RE: SUB19-002/SEP19-005 – Proposed Preliminary Plat  
2825 W. Mercer Way, APN 2174502425  
Request for Additional Information, Third Review  
Blueline Job No. 13-118

This letter is in response to your review of the SUB19-002/SEP19-005 project. The plans have been revised per the comments in your letter dated 1/09/23. Below is a list of each comment with our responses in bold.

2/16/23
JOB NUMBER: 13-118
SHEET NAME: RS-01
SHT 6 OF 9

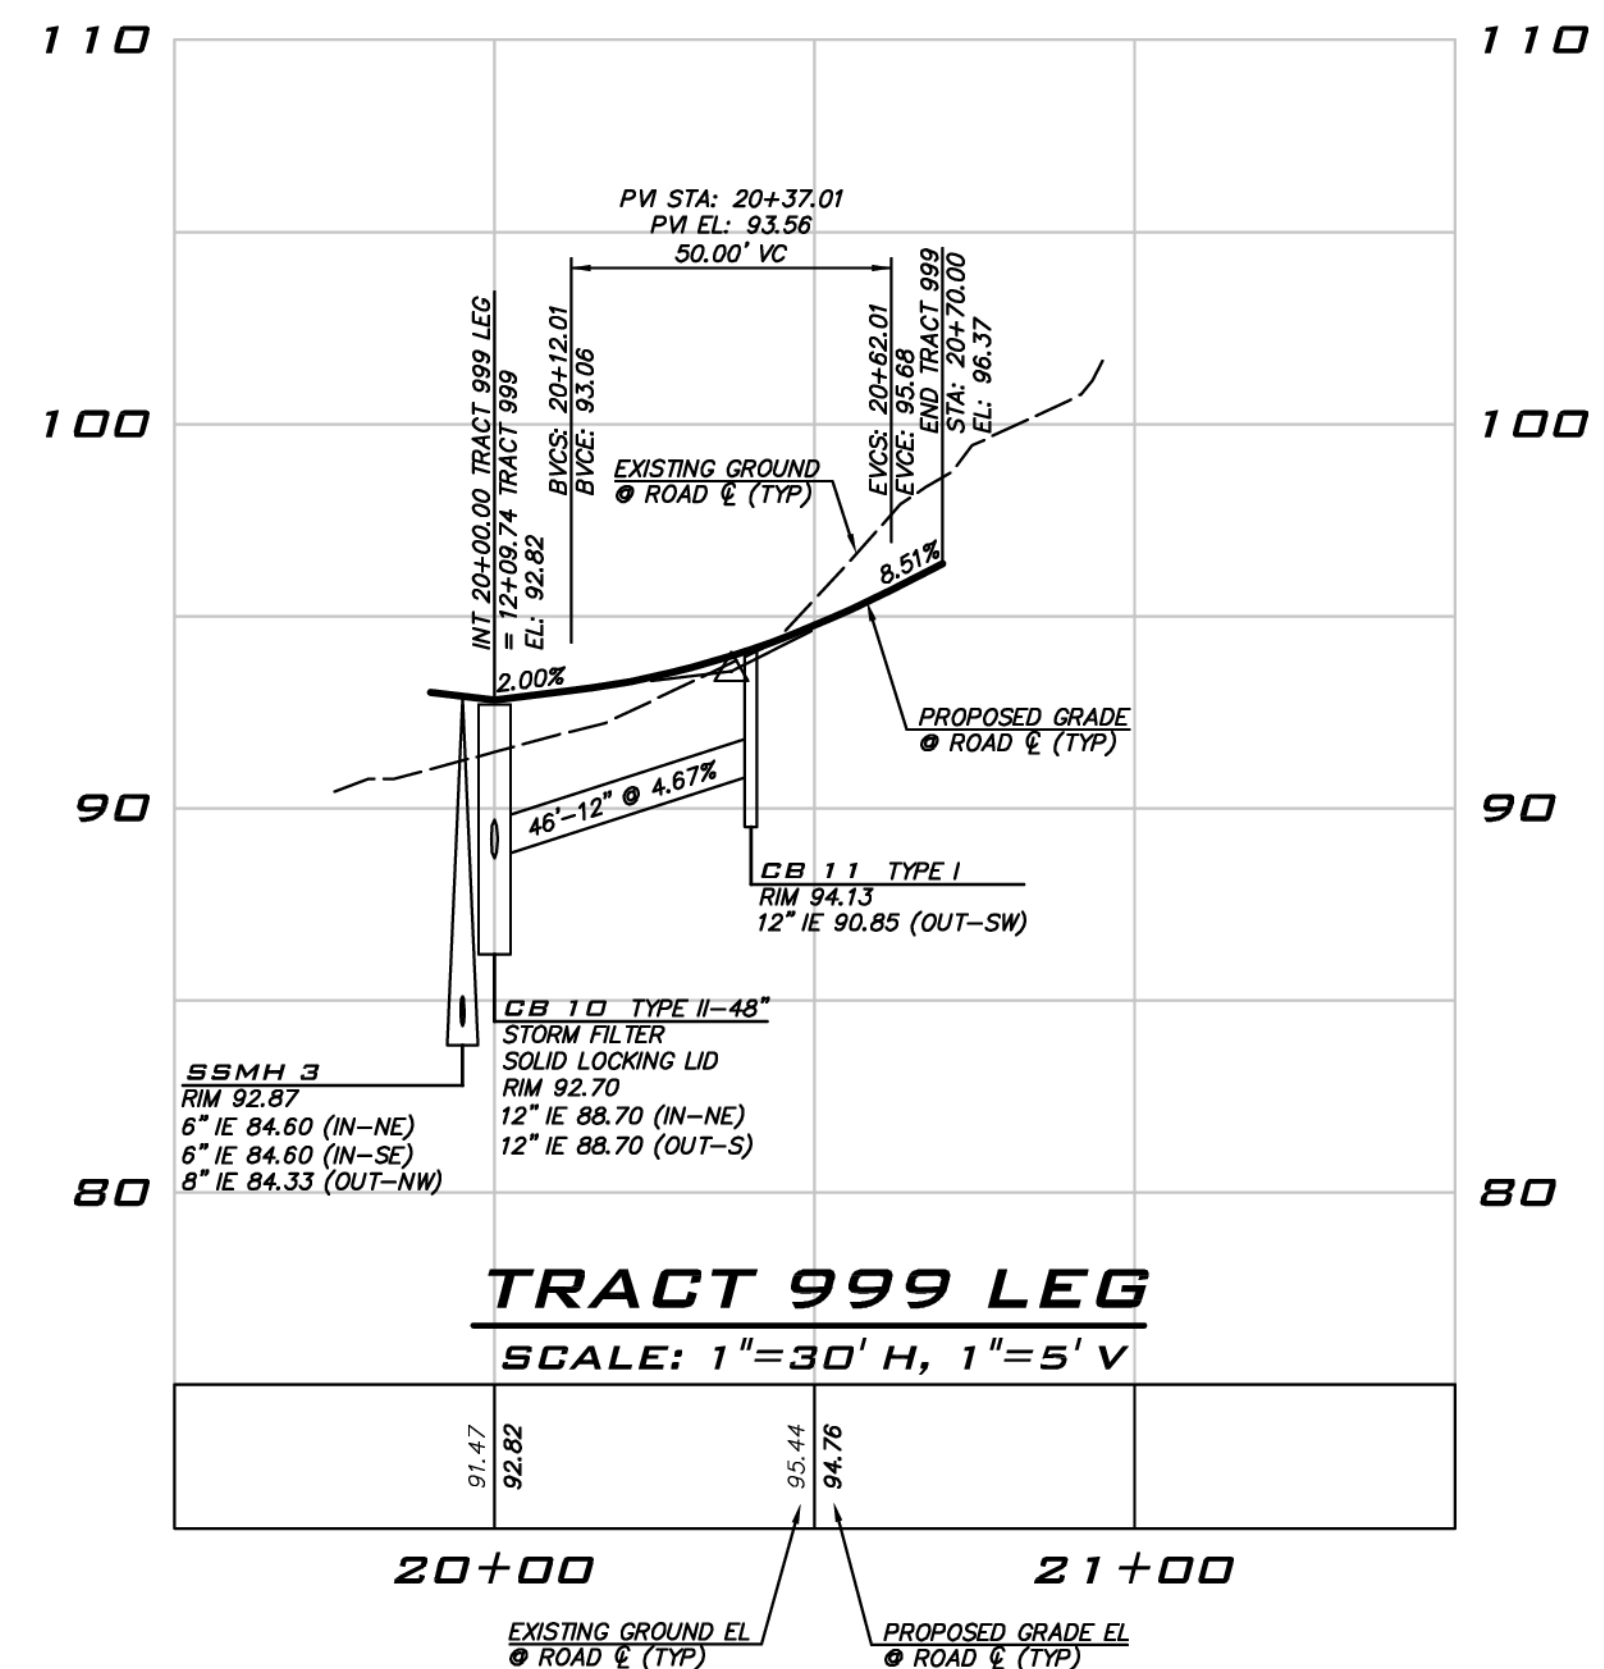
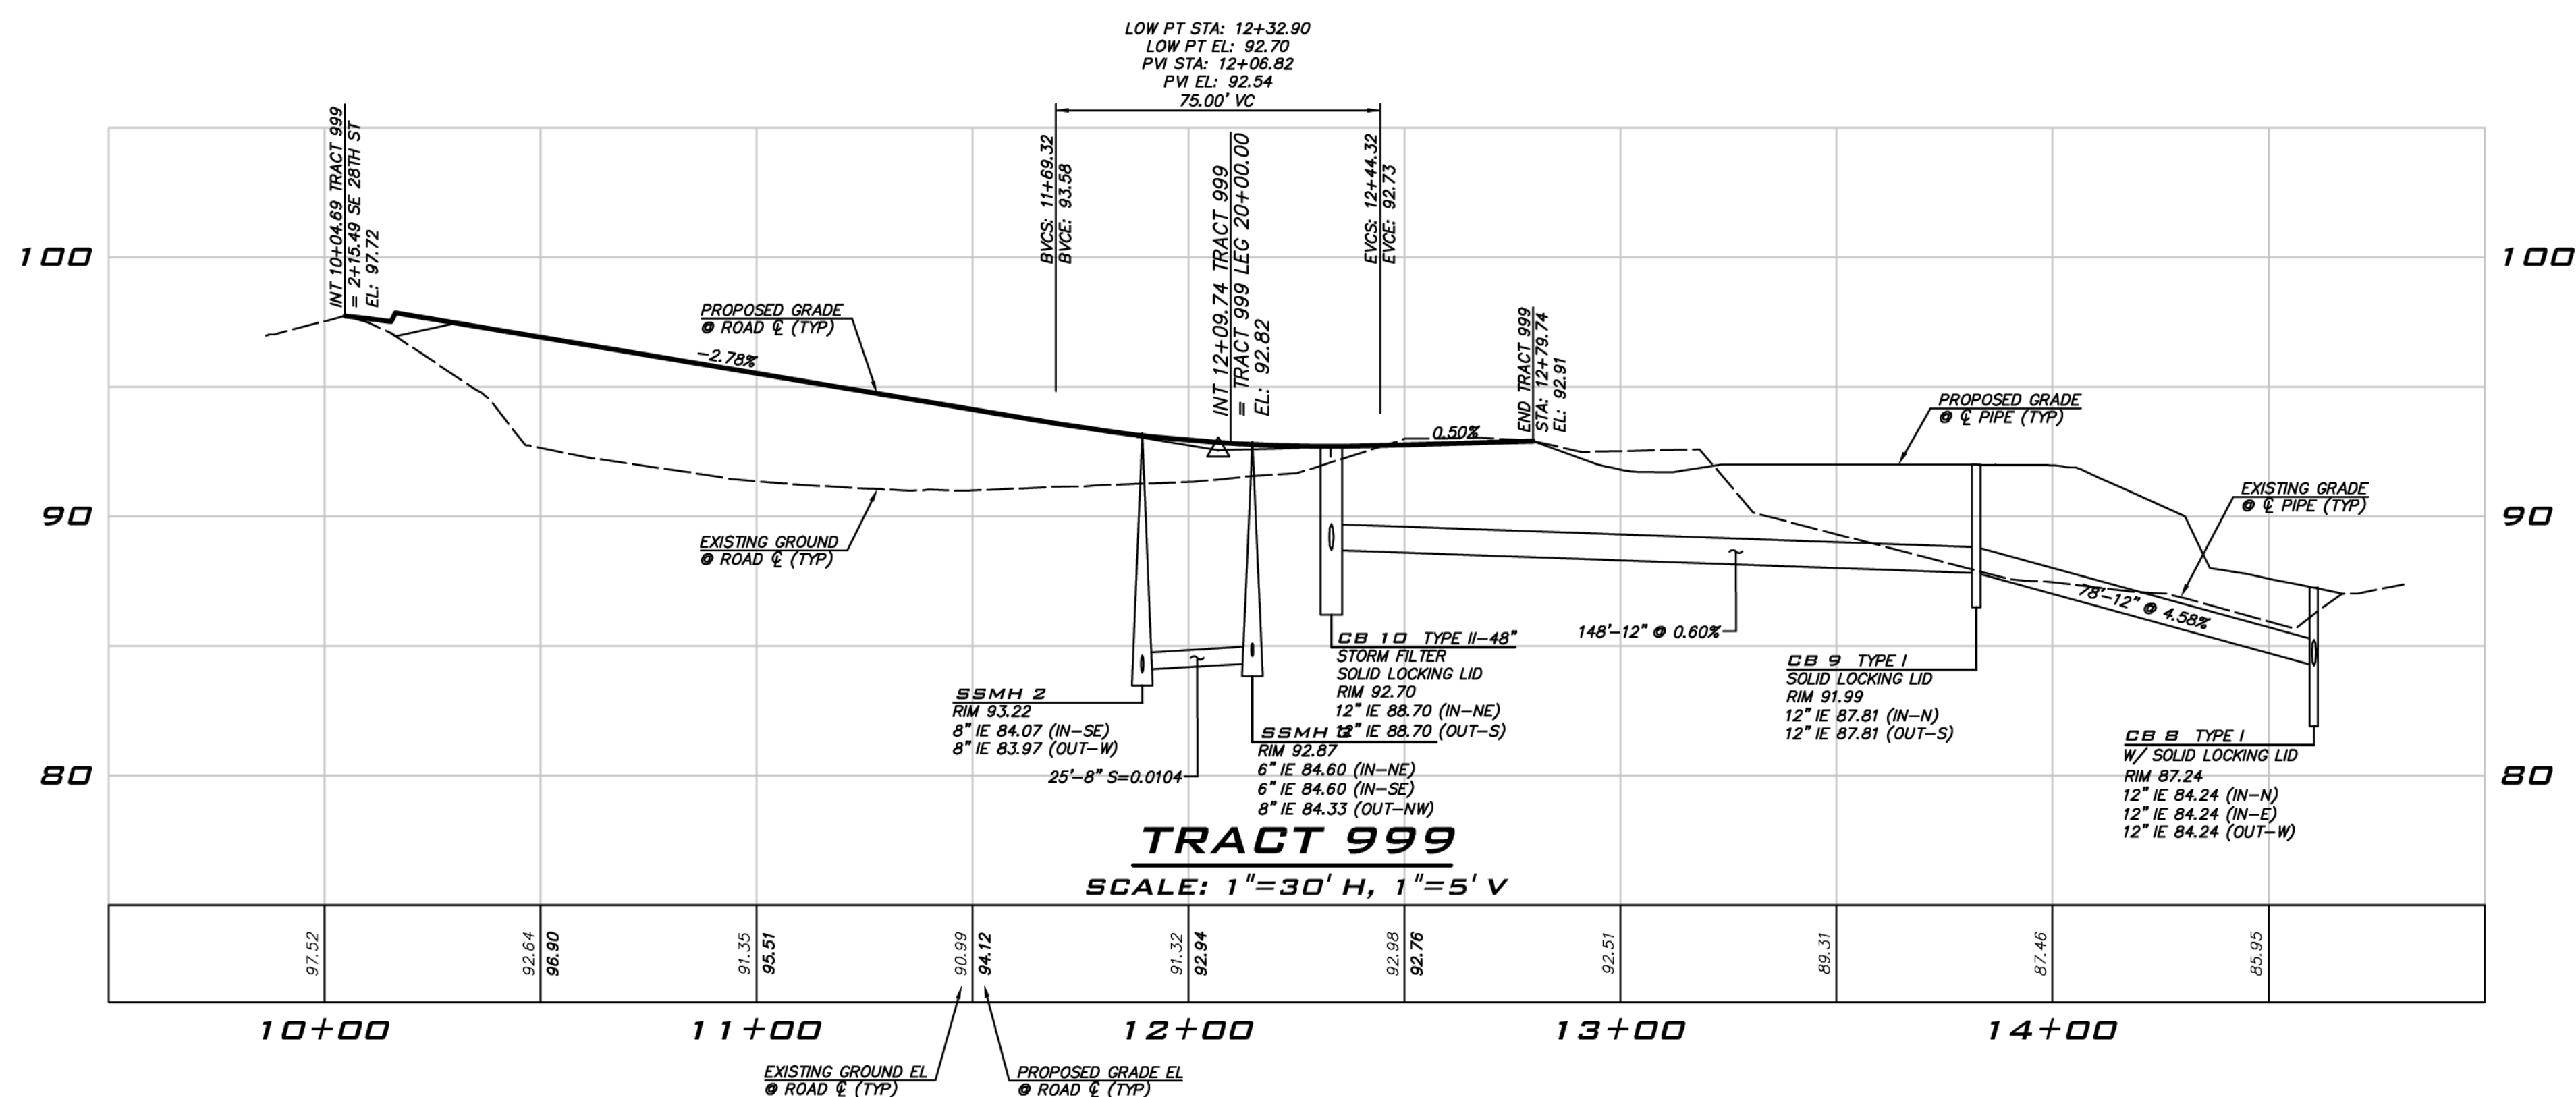
7. Fire Turn Around- Meets Standards  
IFC 503.2.4 The required turning radius of a fire apparatus access road shall be determined by the fire code official. (See Appendix B)  
Applicant must identify turn around area on plat map and provide a plan on how this area will be maintained for fire access only and not parked vehicles. Examples would be painted lines (maintenance agreement) and/or signage.

**Noted. A callout for the fire turnaround has been added to sheets SP-01 and RS-01.**
